# memorandum

date January 30, 2023  
to Ryan Harriman, City of Mercer Island  
from Emily Heim, ESA  
subject Review of 5637 East Mercer Way- Permit Application (2204-107)

SITE PLAN
5637 MERCER WAY
MI TREEHOUSE, LLC
 11030 SE 30TH ST
 BELLEVUE, WA 98004

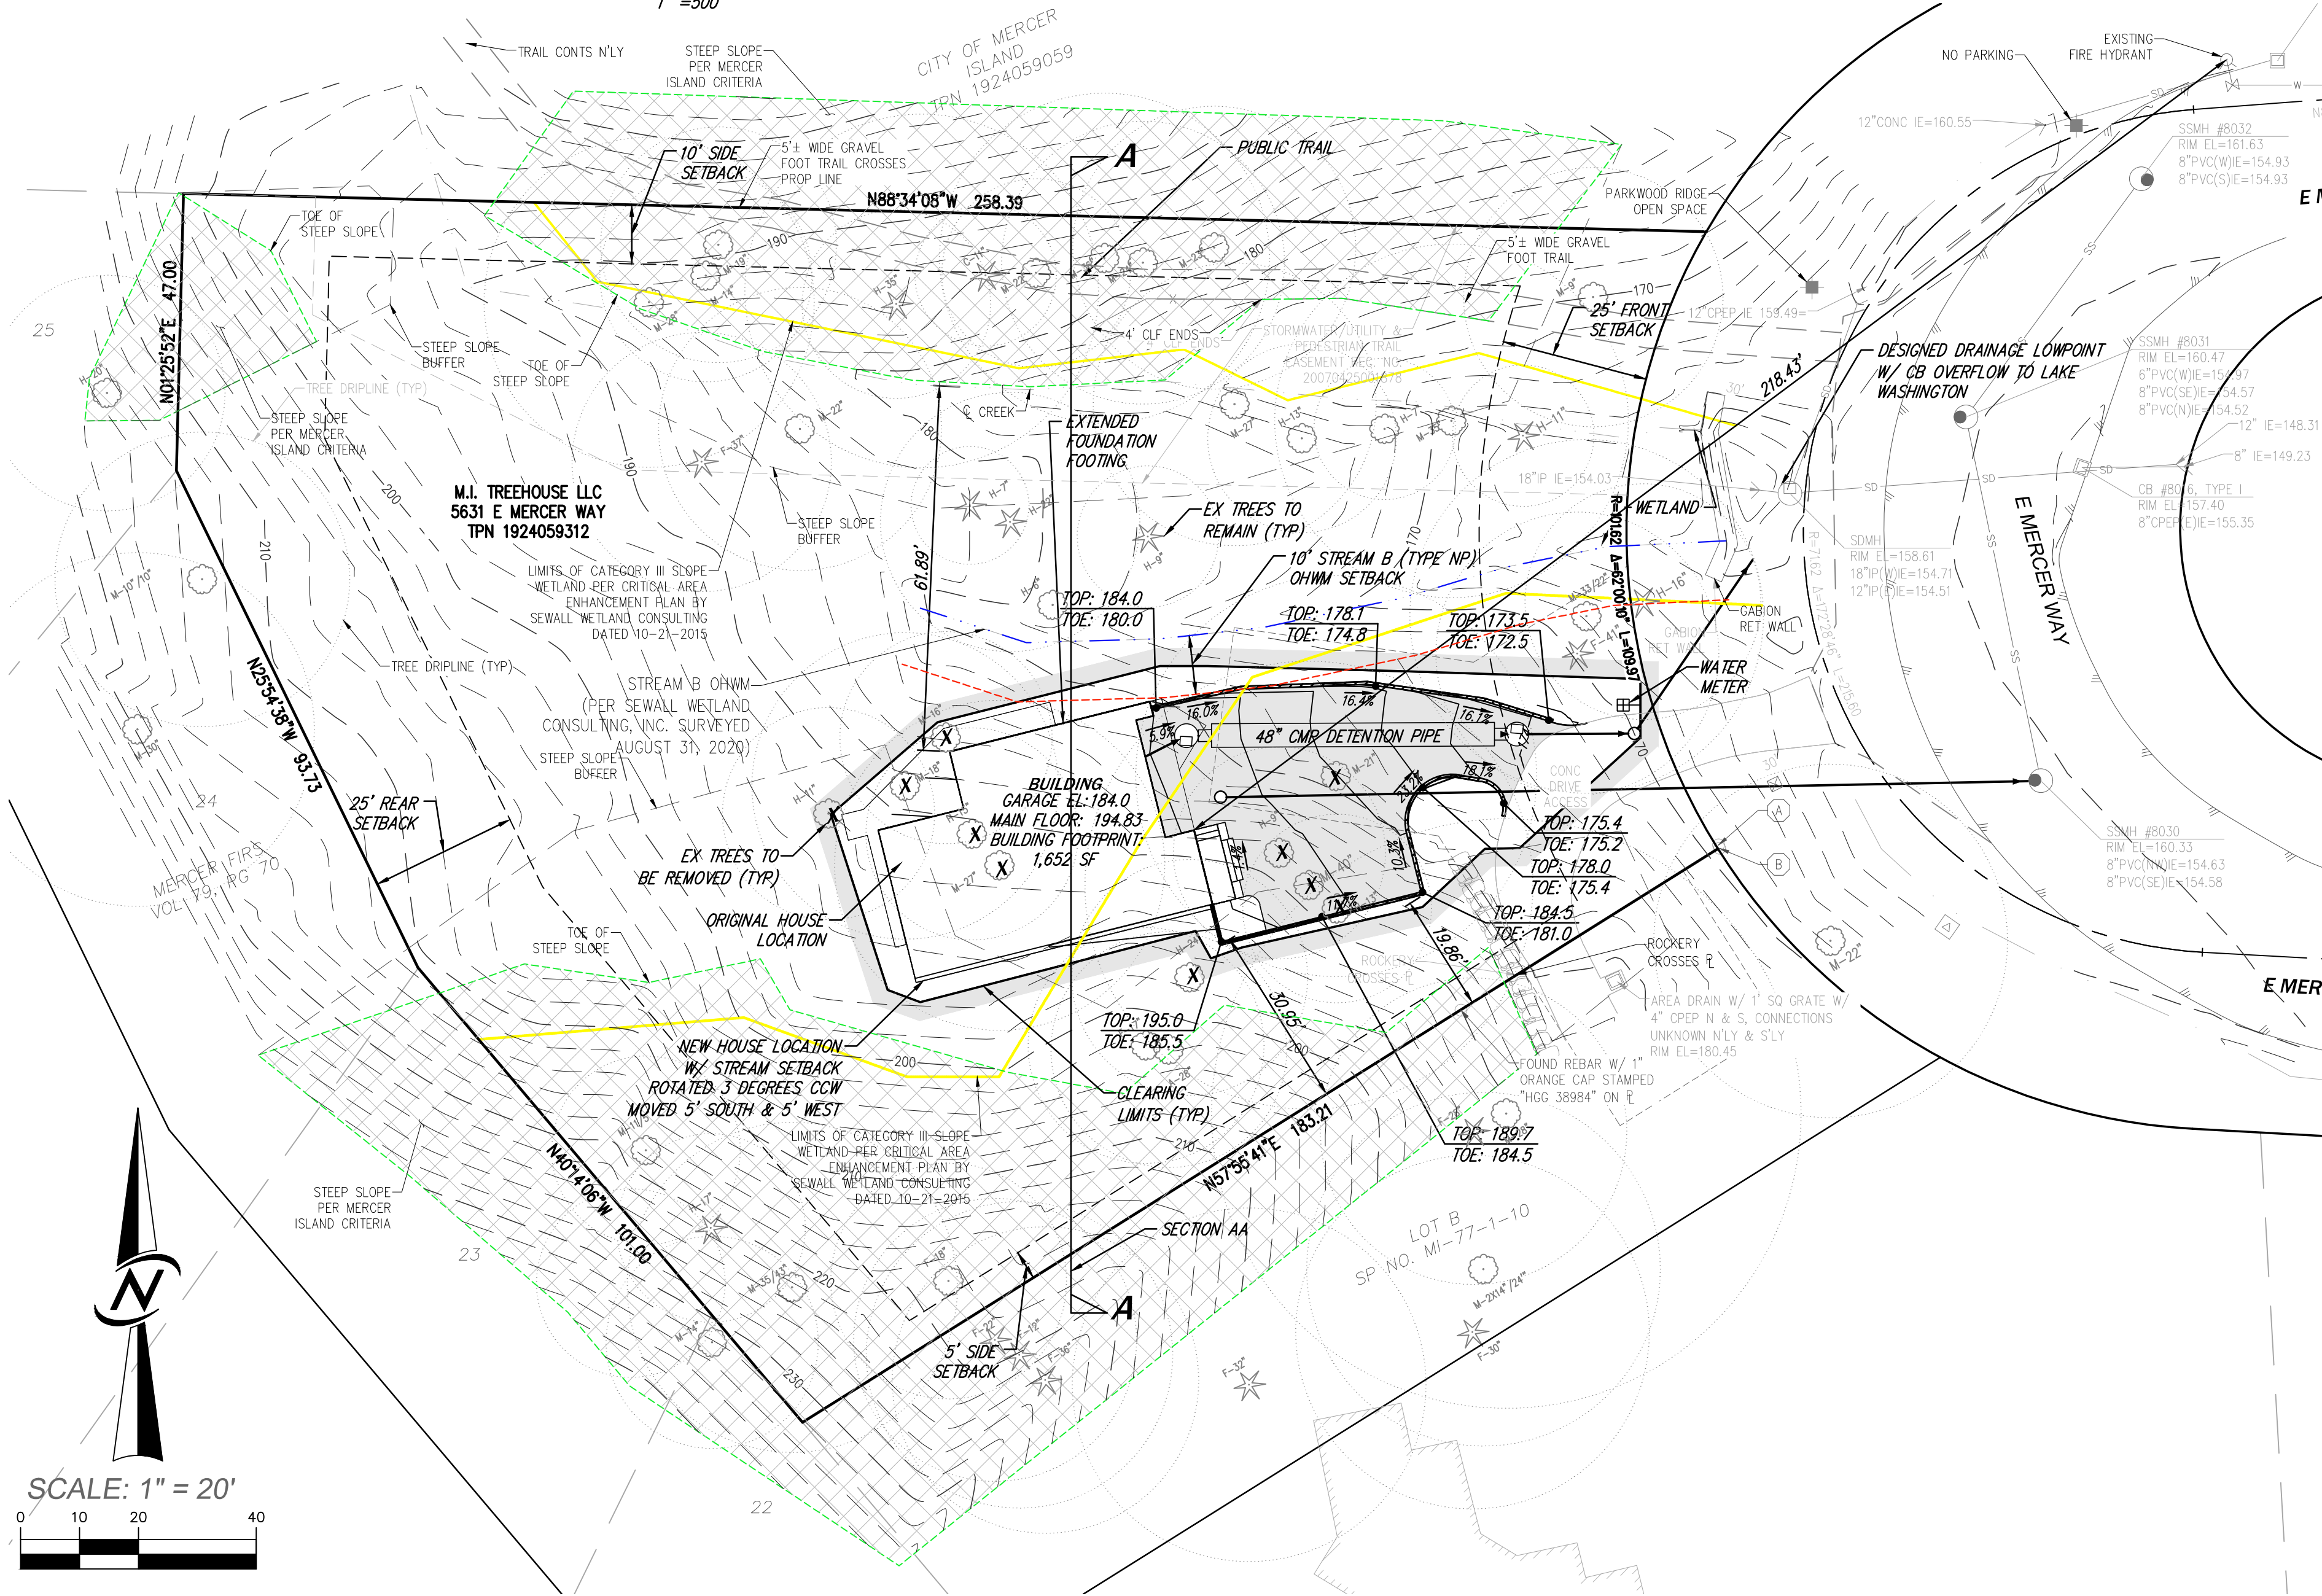
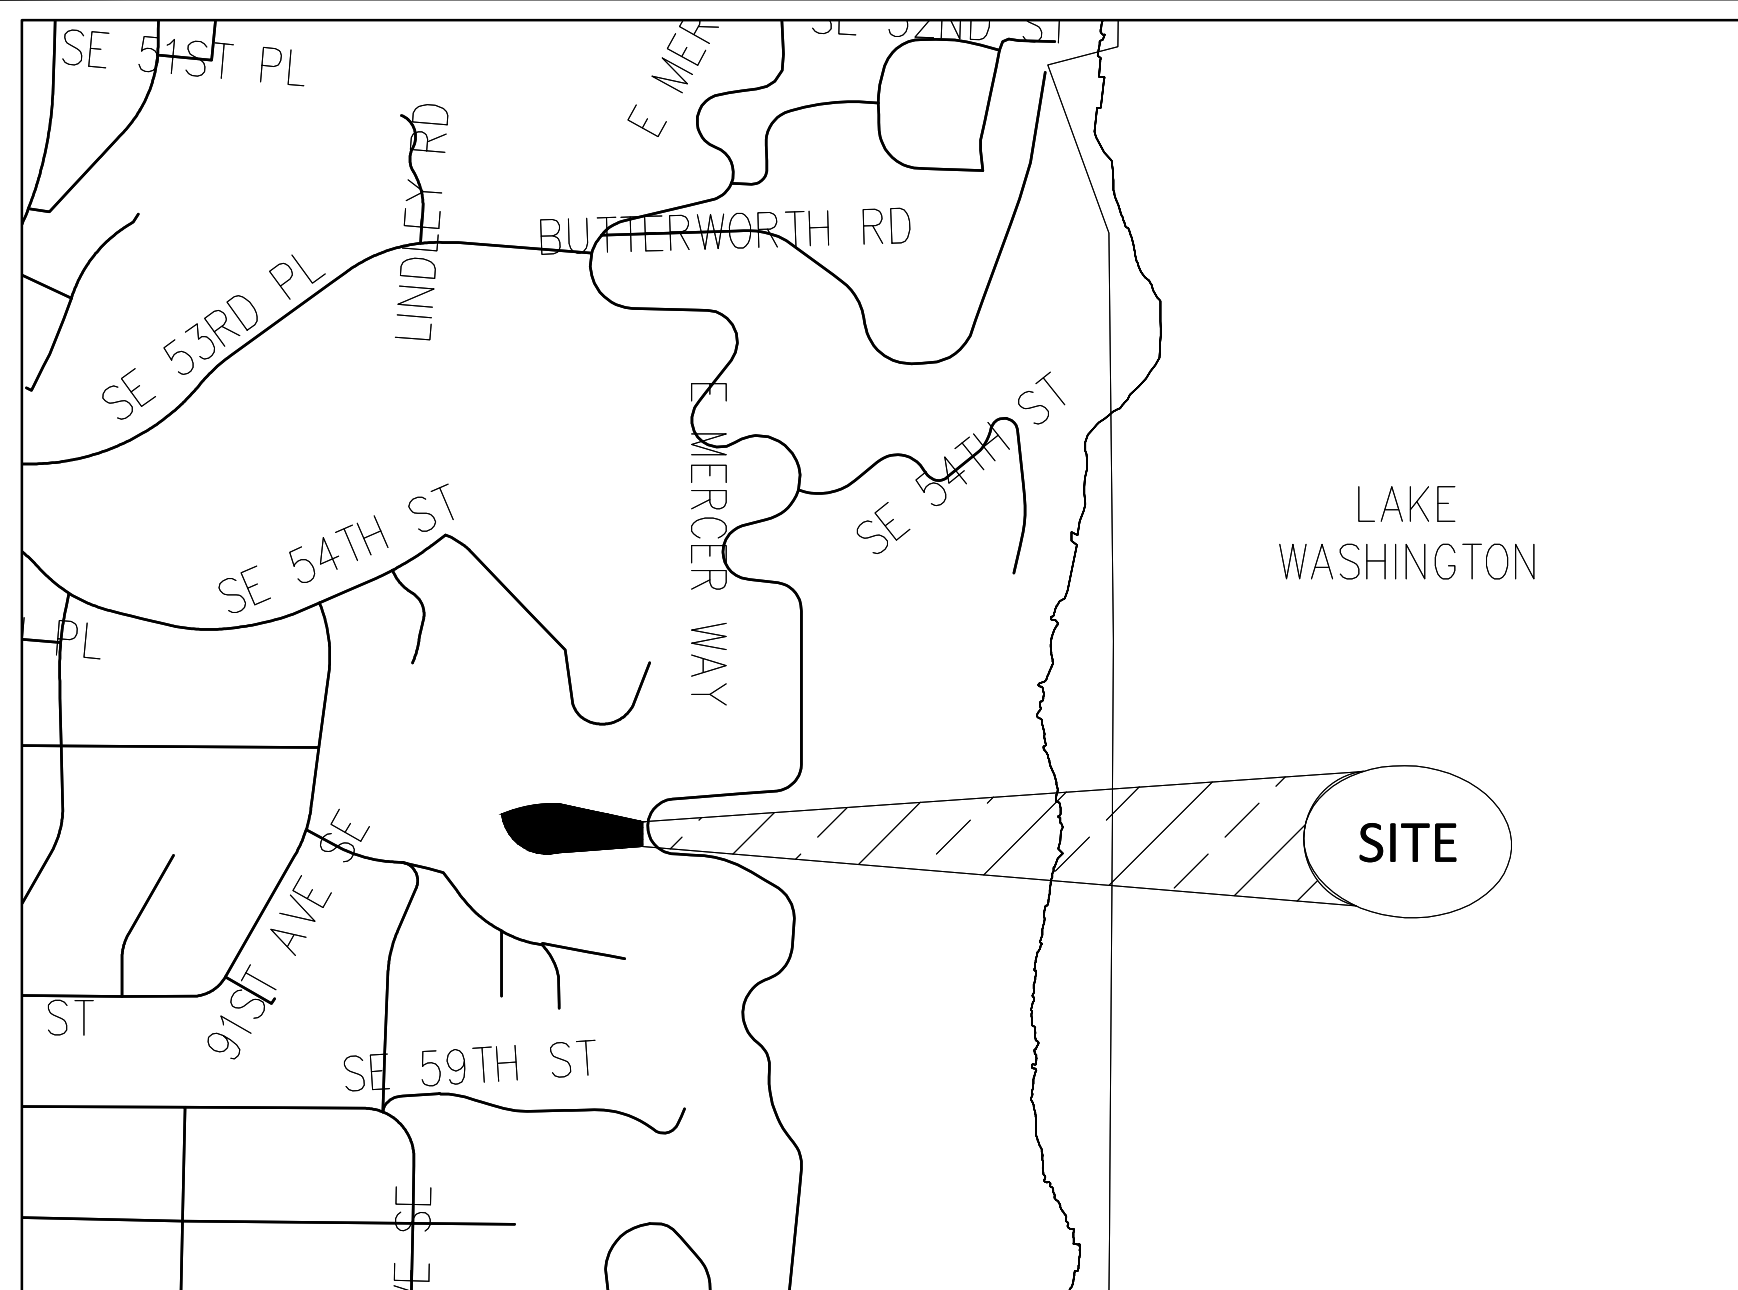
- A. Except as otherwise required by the conditions of approval contained herein, construction of the proposed single-family dwelling, driveway access, and other site improvements shall be completed in substantial compliance with the Site Plan by Core Design, received August 2, 2021 (Exhibit 87b).

*Condition met. ESA recommended the Site Plan be updated to include the split rail fence as described in Condition of Approval I determined by the Hearing Examiner December 15, 2021. These changes are reflected on the Complete Plan Set prepared by The Healey Alliance AZ dated October 5, 2022.*

- I. Upon completion of construction and prior to final inspection and approval for occupancy by the City, the developer shall have installed a split rail or equivalent fence around the north, west, and south sides of the clearing limits as depicted on Exhibit 87b.

*Condition will be met according to the Complete Plan Set dated October 5, 2022. See Response to ESA's June 29, 2022 Recommendation 2.*

2. The Site Plan did not show a split rail fence around the north, west, and south extent of the clearing limits. ESA recommended the Site Plan be updated to include the split rail fence as described in the Conditions of Approval determined by the Hearing Examiner December 15, 2021. This has been updated. The correction is shown on the Site, Storm, Utilities & Grading Plan & Notes Sheet (page 45) of the *Complete Plan Set* prepared by The Healey Alliance AZ dated October 5, 2022.
